PORTLAND MAINE

January 13, 2010

RE: 92 William Street – 117-C-9 & 11 – R-5 Residential Zone

I am in receipt of your request to determine whether the proposed lot division will not violate any of the Land Use Zoning Ordinance requirements. My determination is based upon an unsigned and unstamped survey prepared by Owen Haskell, Inc. labeled “Boundary Survey on William Street, Portland, Maine made for record owner Ernest Brien, 92 William Street, Portland, Maine”, Job No. 2009-029P dated Dec. 28, 2009. If the signed and stamped survey differs from the one given to me to examine, then this determination letter is not valid.

Plot Plan

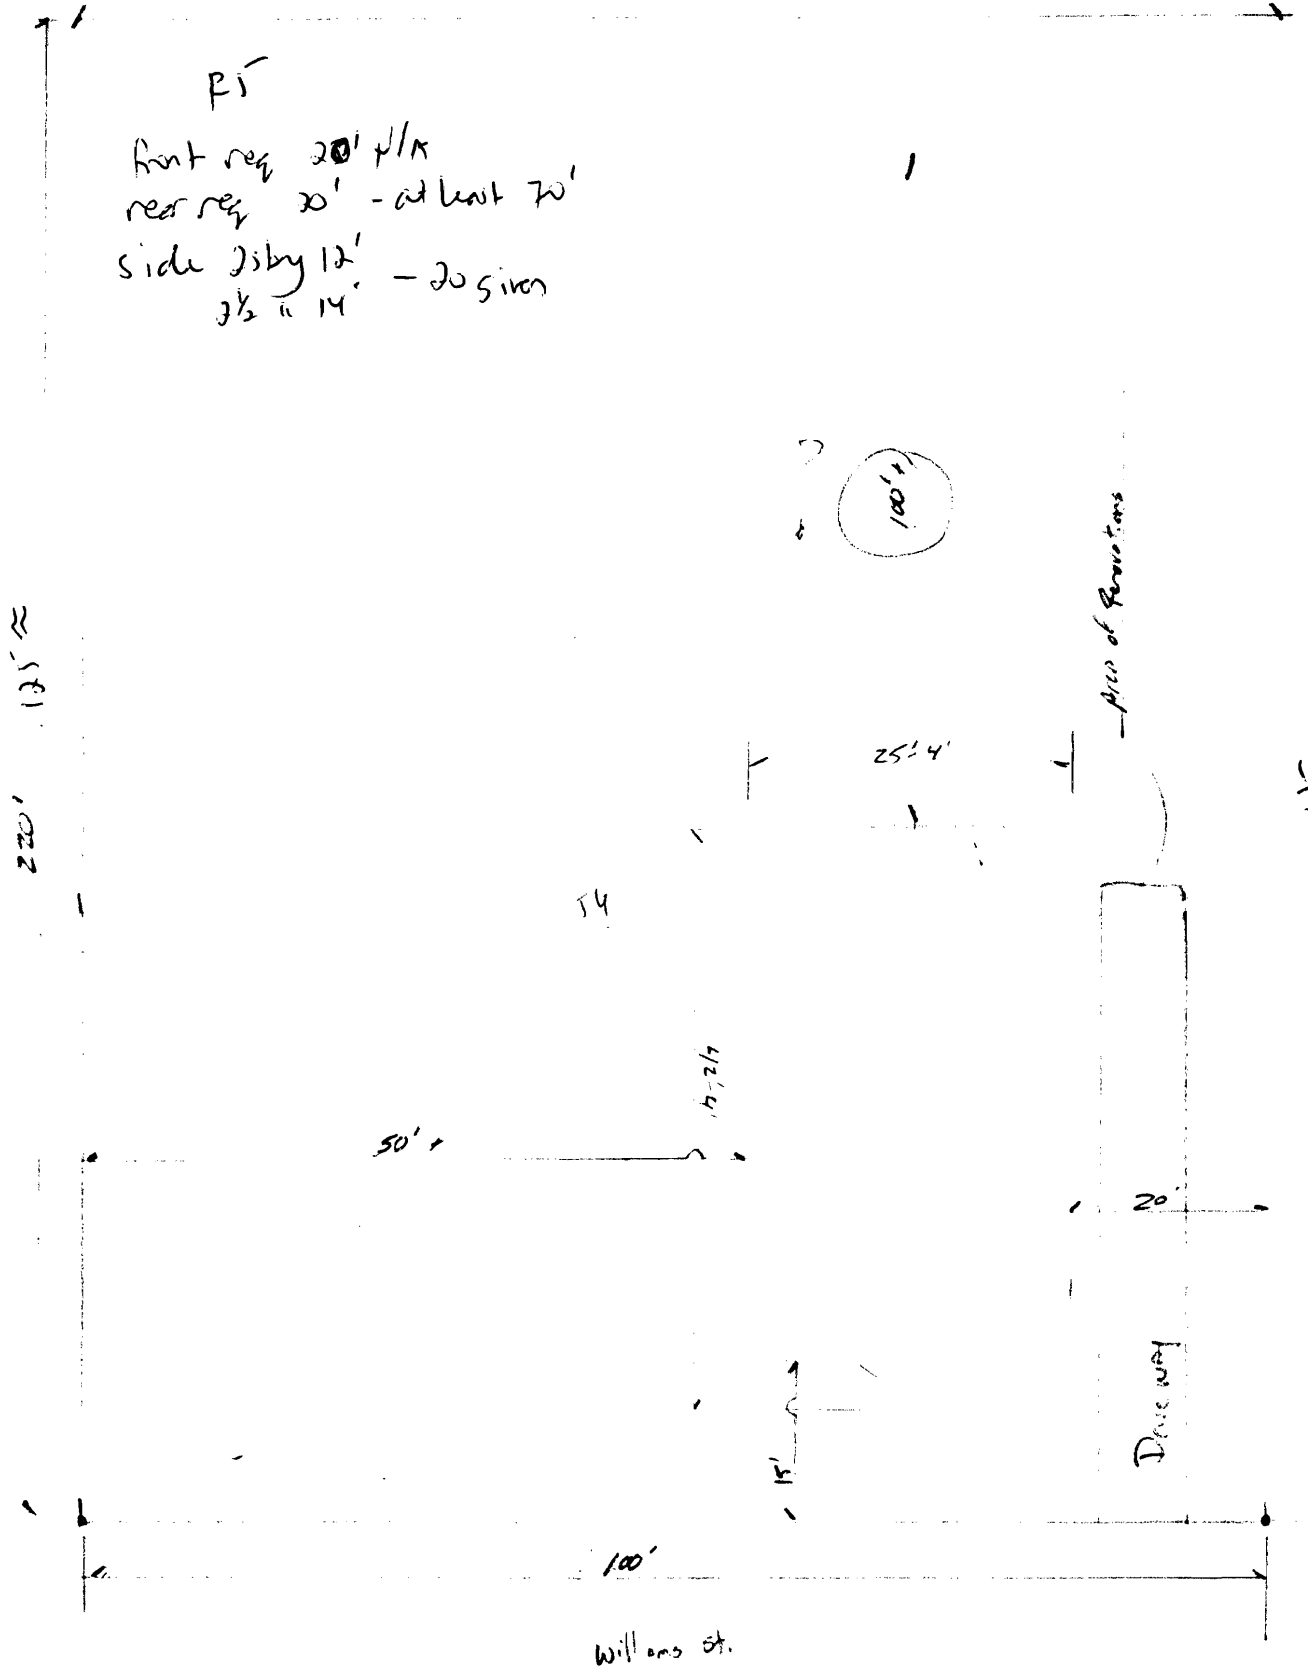
The division of land based upon the Owen Haskell, Inc. survey does meet all the R-5 Zone requirements with one exception. The existing shed (6' x 6.5') shall be removed or relocated with a building permit to insure appropriate placement. The current shed is made to be nonconforming by the placement of the new property lines. Certainly before this office will approve any new building permit, the shed shall be moved or removed.

There is a note of caution for the new vacant lot. A front setback of 20 feet is required in the R-5 Zone. The front setback is measured from the orientation of the proposed structure forward toward the street line. I caution that the section of property line indicated as “S60°33'46”W – 24” is considered to be a line that a front setback will be measured to if a structure is located behind it. With a required front setback of 20' and a rear setback of 20', a structure located in this area of the lot will be only about 15' wide.
